Application for a non-material amendment following a grant of planning permission.

Number	
Suffix	
Property name	Kite Surf Centre and Cafe
Address line 1	Kite Surf Centre and Cafe, Sea Road
Address line 2	
Address line 3	
Town/city	Littlehampton
Postcode	BN16 2NA
Description of site location must be completed if postcode is not known:	
Easting (x)	503976
Northing (y)	101344
Description	
Demolition of promenade shelter & construction of café & kite surfing school with roof terrace and associated works

6. Non-Material Amendment(s) Sought

Drawing **CND1_SK01** Rev **a**
Date **OCT 2019** Scale **1 : 100 at A3**

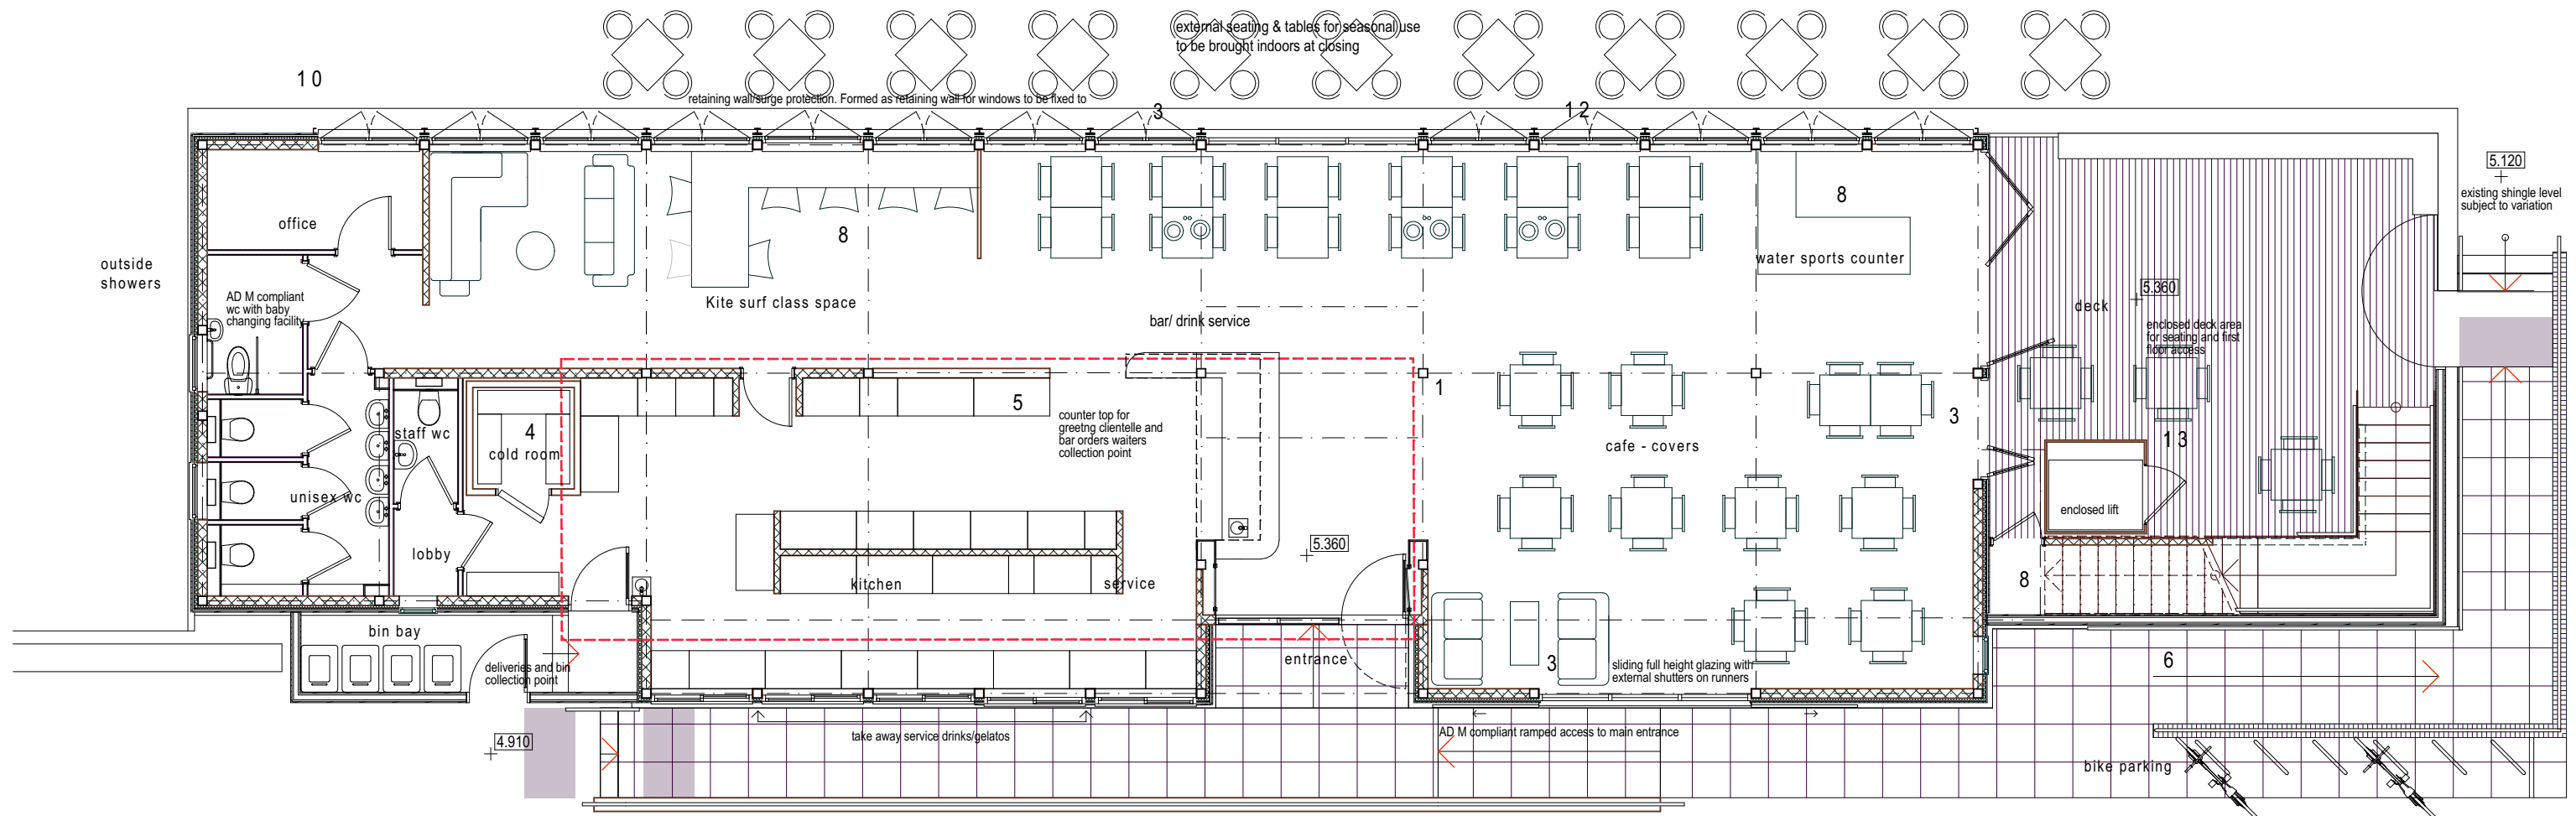
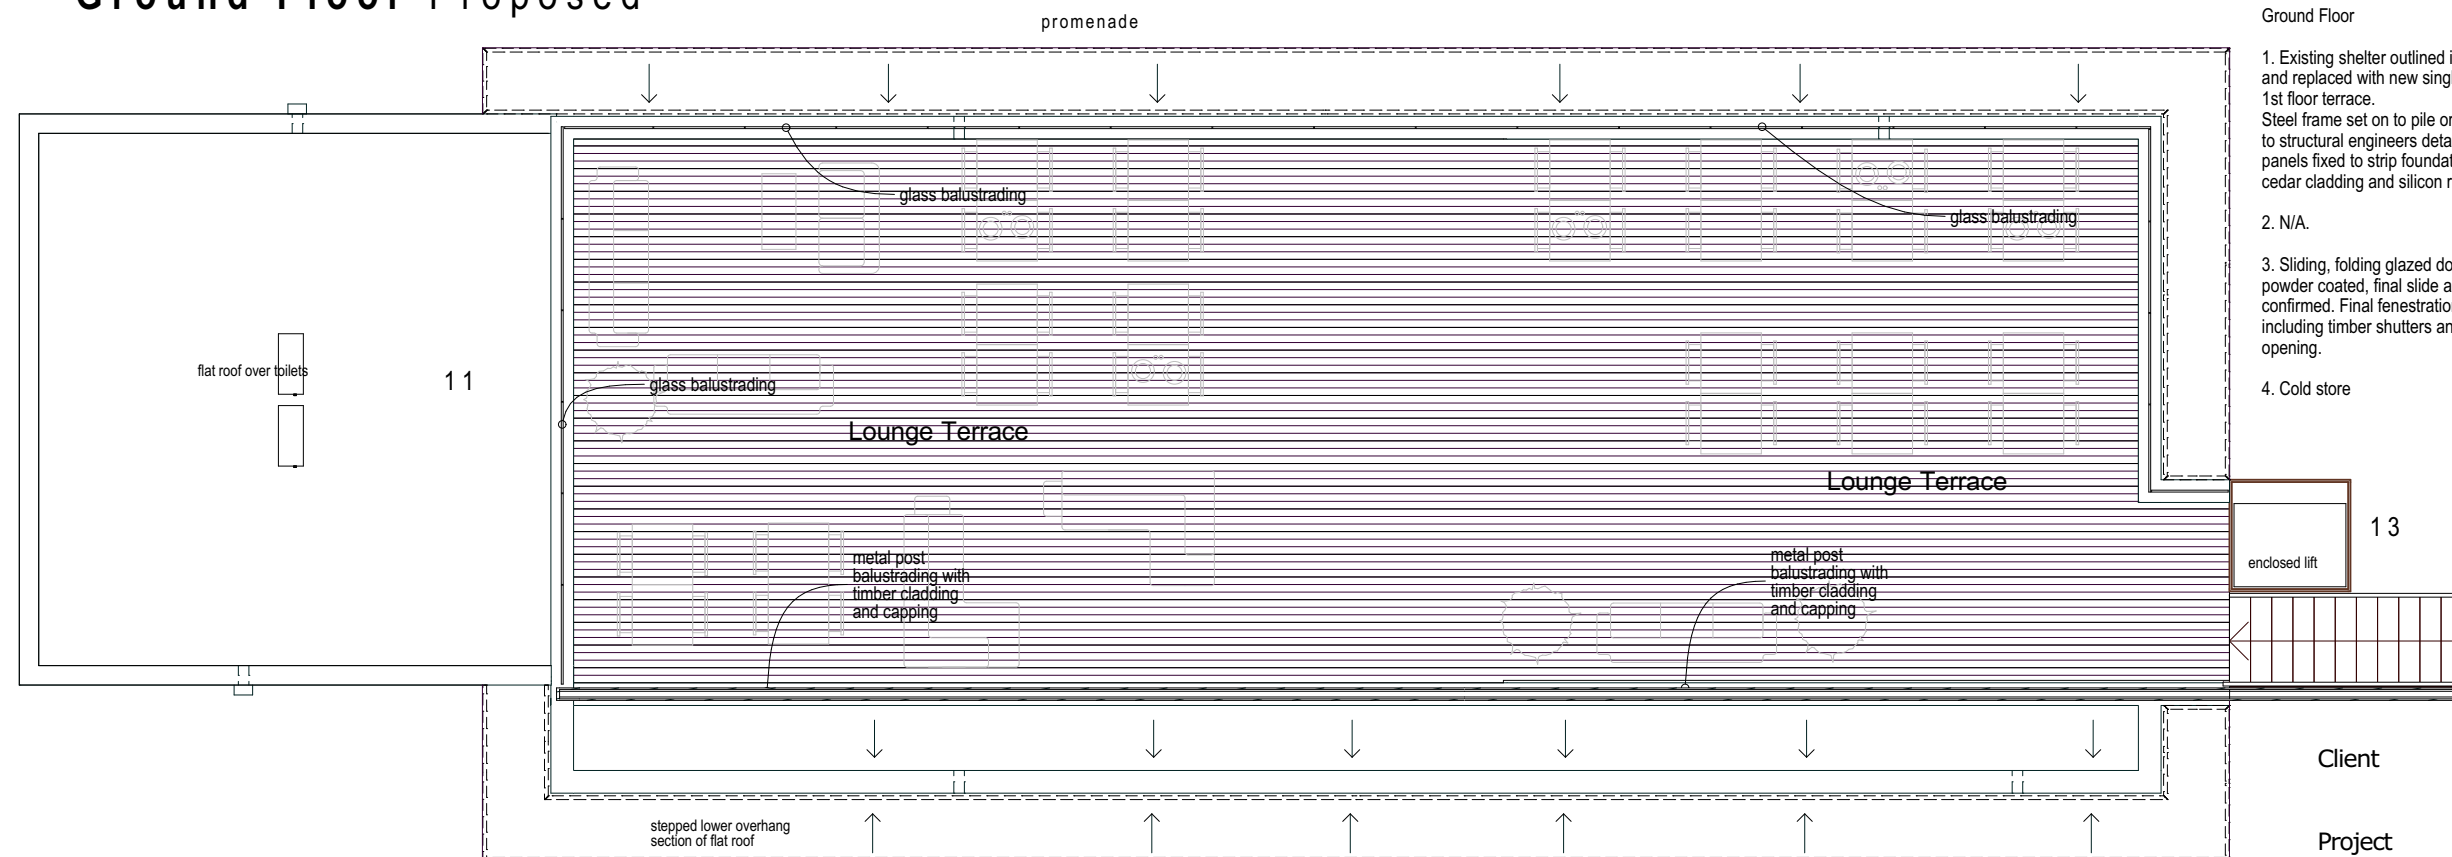
1. Change of exterior material from render to cedar boarding to match remainder of building.
2. Removal of raised light boxes at first floor terrace level.
3. Removal of external picnic table bench seating to be replaced with loose tables and chairs.

1. Simplify design and construction, reduce future maintenance problems
2. Simplify design and construction, reduce future maintenance problems
3. To make storage more practical and reduce possibility of theft and vandalism.
